Please ask for: Mrs D Johnson
Email: daun.johnson@arun.gov.uk
Telephone: 01903 737762
Our Ref: BN/53/21/PL
Your Ref:
Date: 6th May 2021

Application for Planning Permission

Development: Creation of 1 No. new dwelling on brownfield (previous use commercial car parking/children's play area associated with holiday let business. This application is a Departure from the Development Plan & is in CIL Zone 3 & is CIL Liable as new dwelling.

Location: Land To The Rear Of Highground House & Orchard End Highground Lane Barnham

LOCATION PLAN 1:1250 @A3

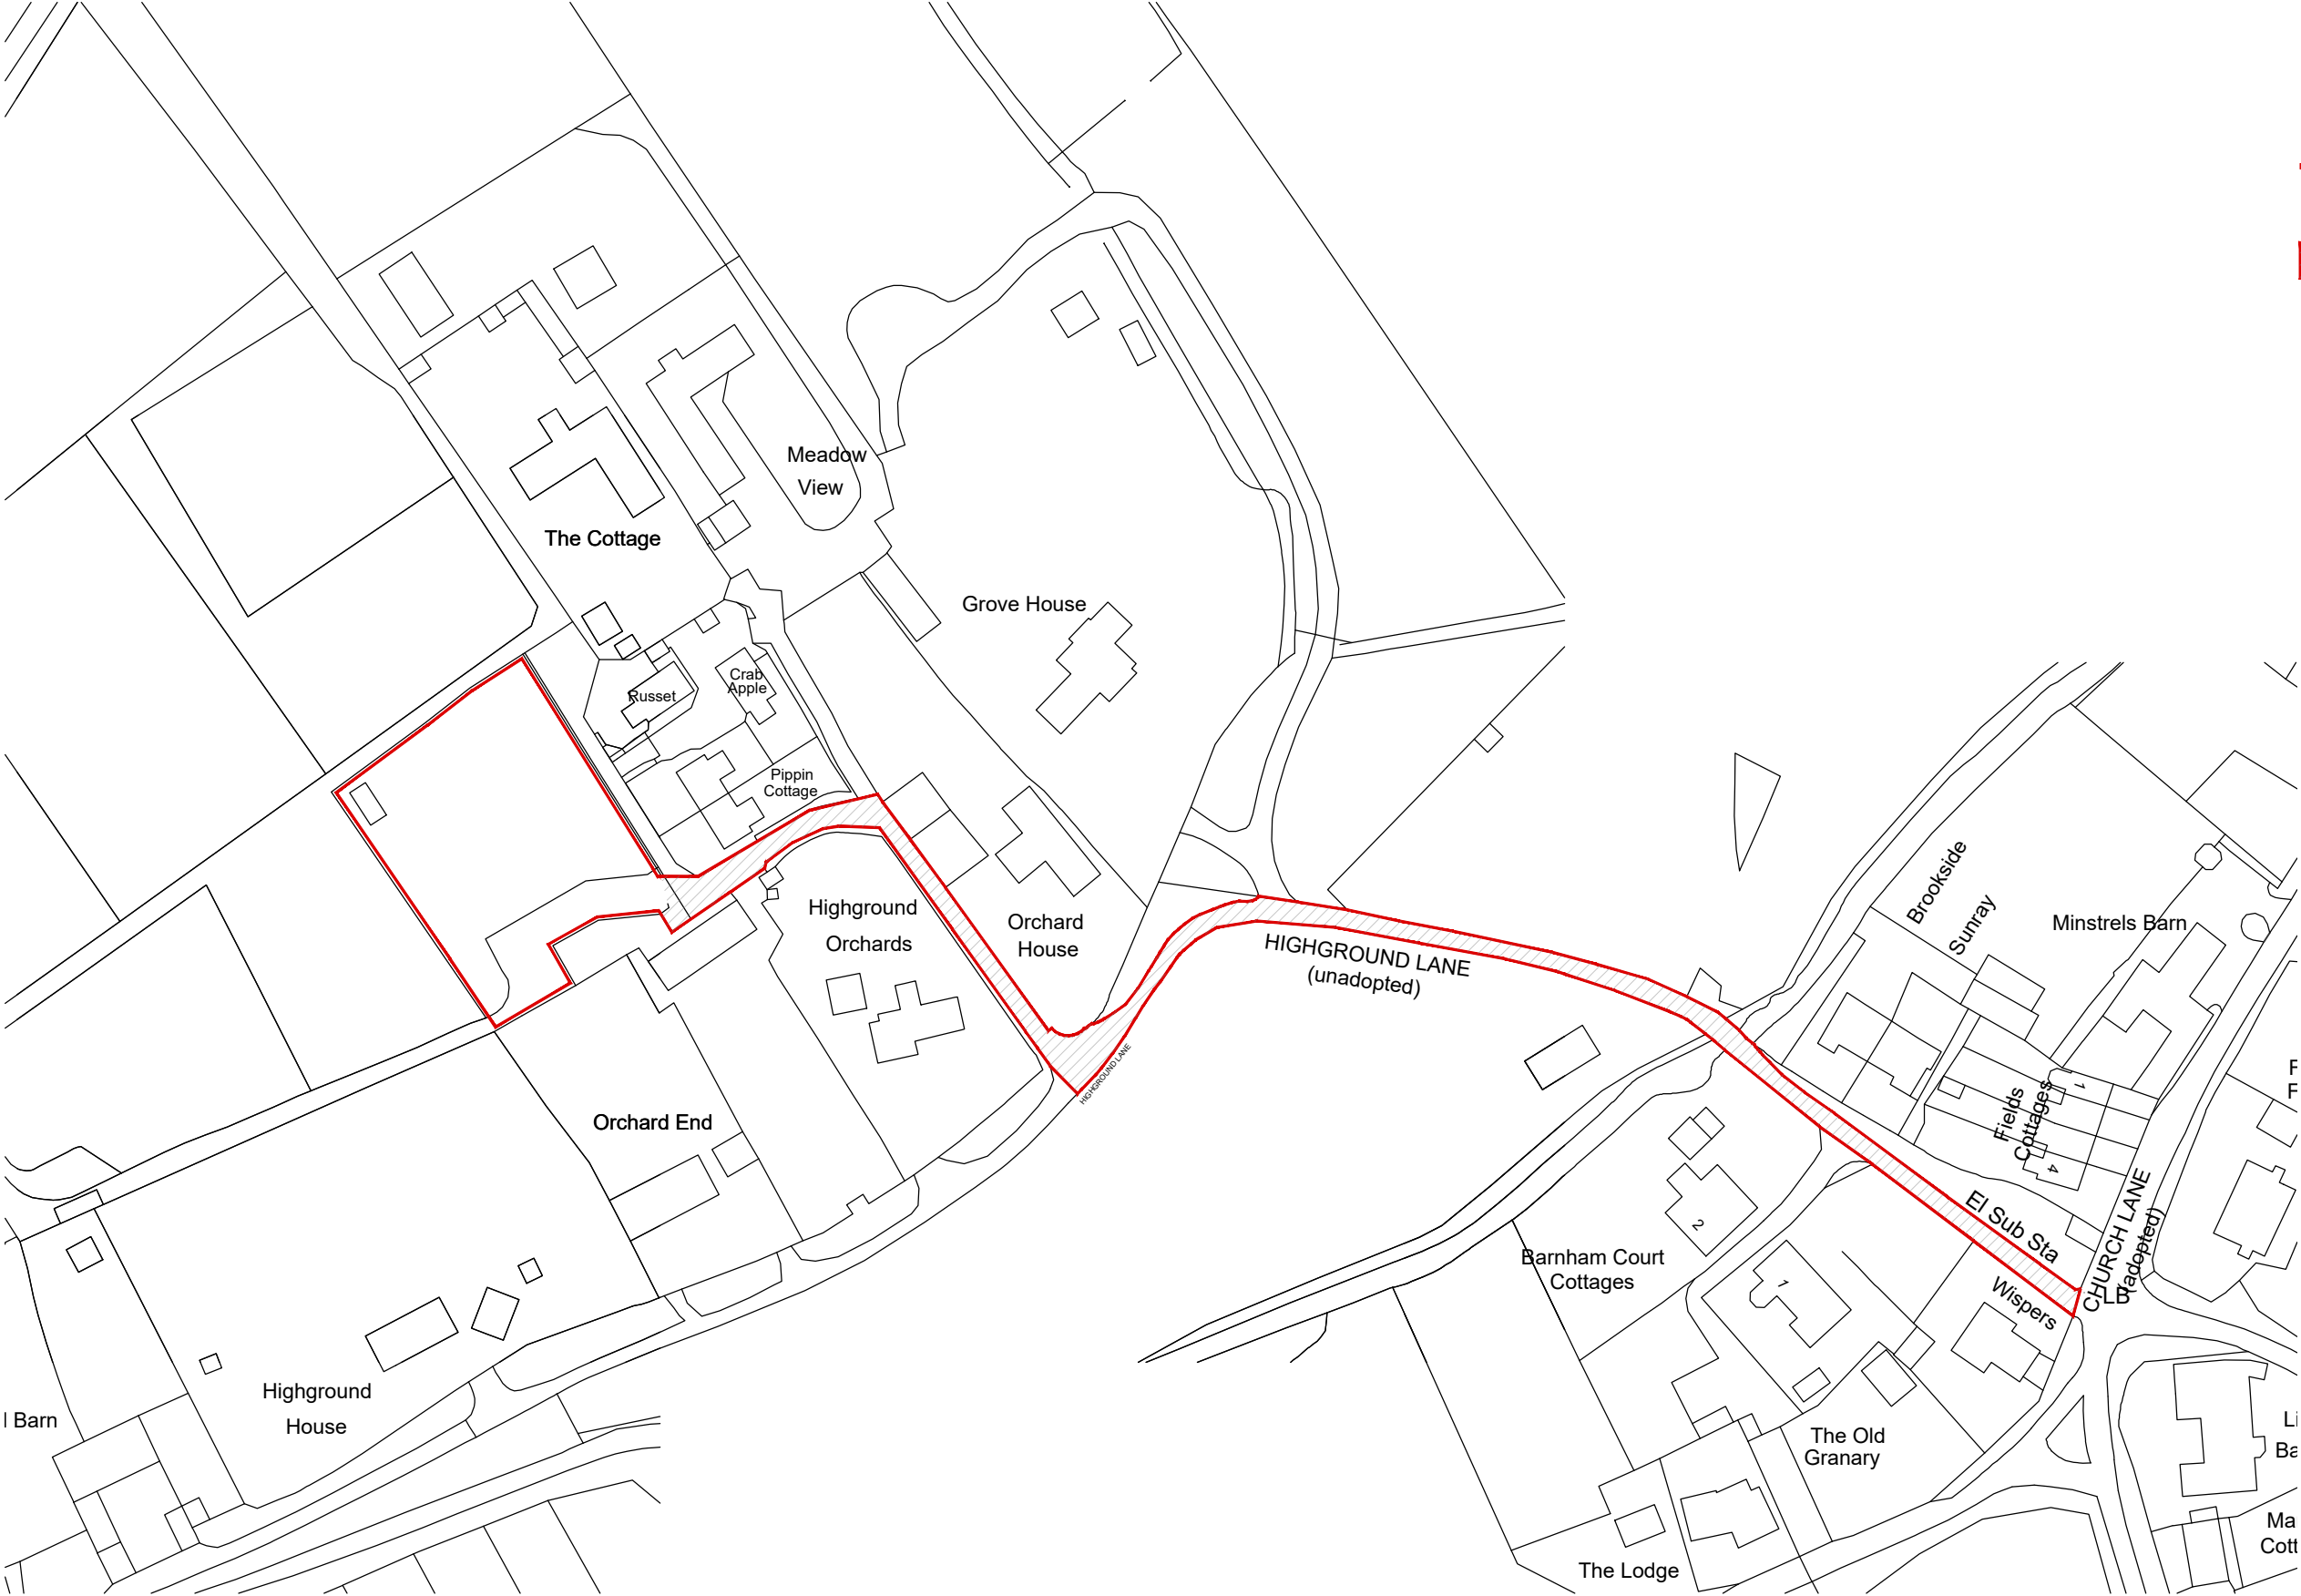
Please only red edge the application site (to include the access) and only blue edge any land adjoining the application site that is in the control/owned by the applicant.
Please confirm the amended site address is satisfactory.
